Permit Number: 061023

has permission to install a 30' x 52" pool w/ spa deck

AT 1646 WESTBROOK ST

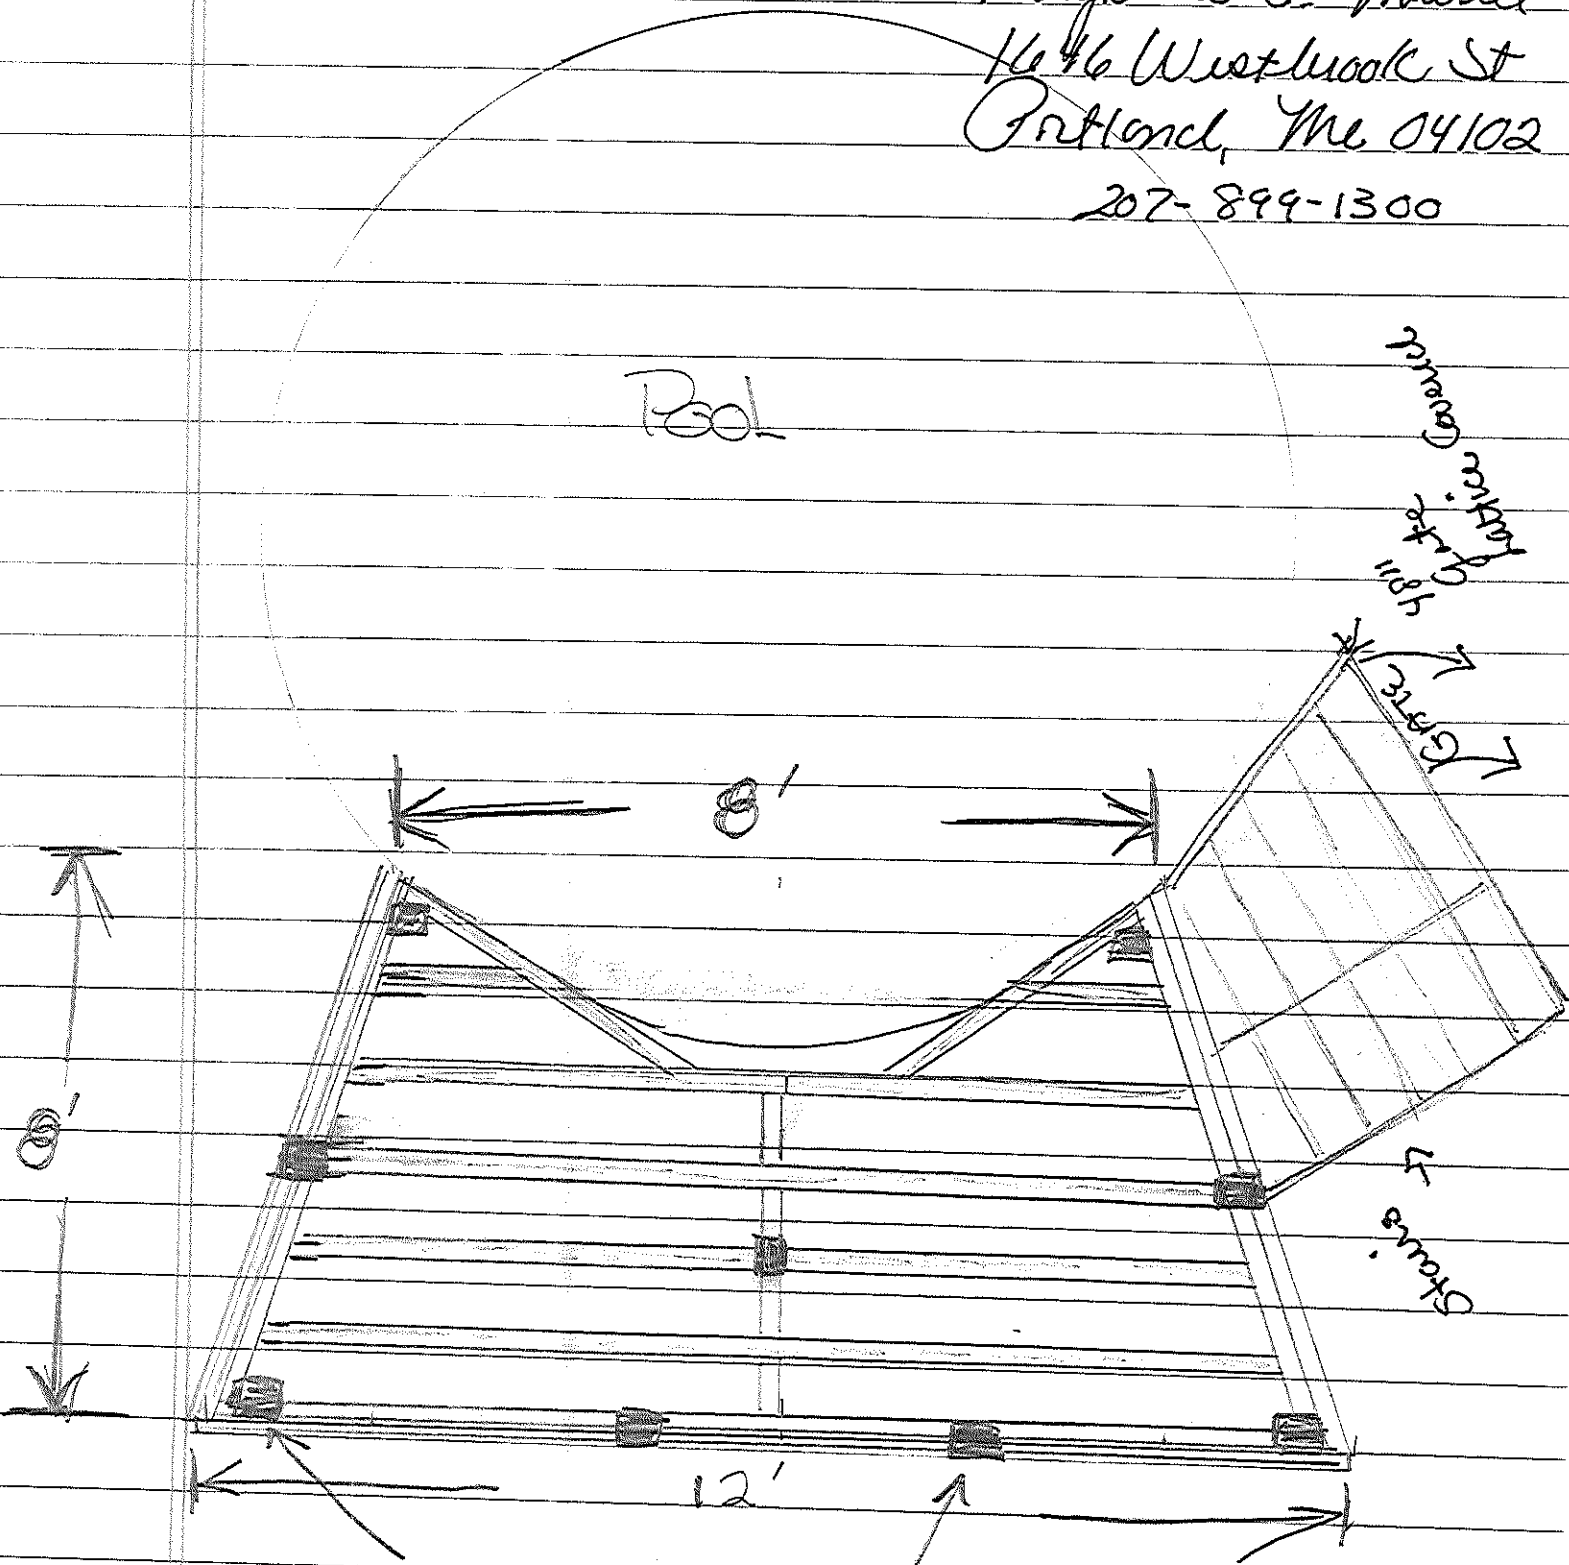
Comments:
7/18/2006-mjn: Left message, need deck framing detail, have a description that does not include Beam Information.
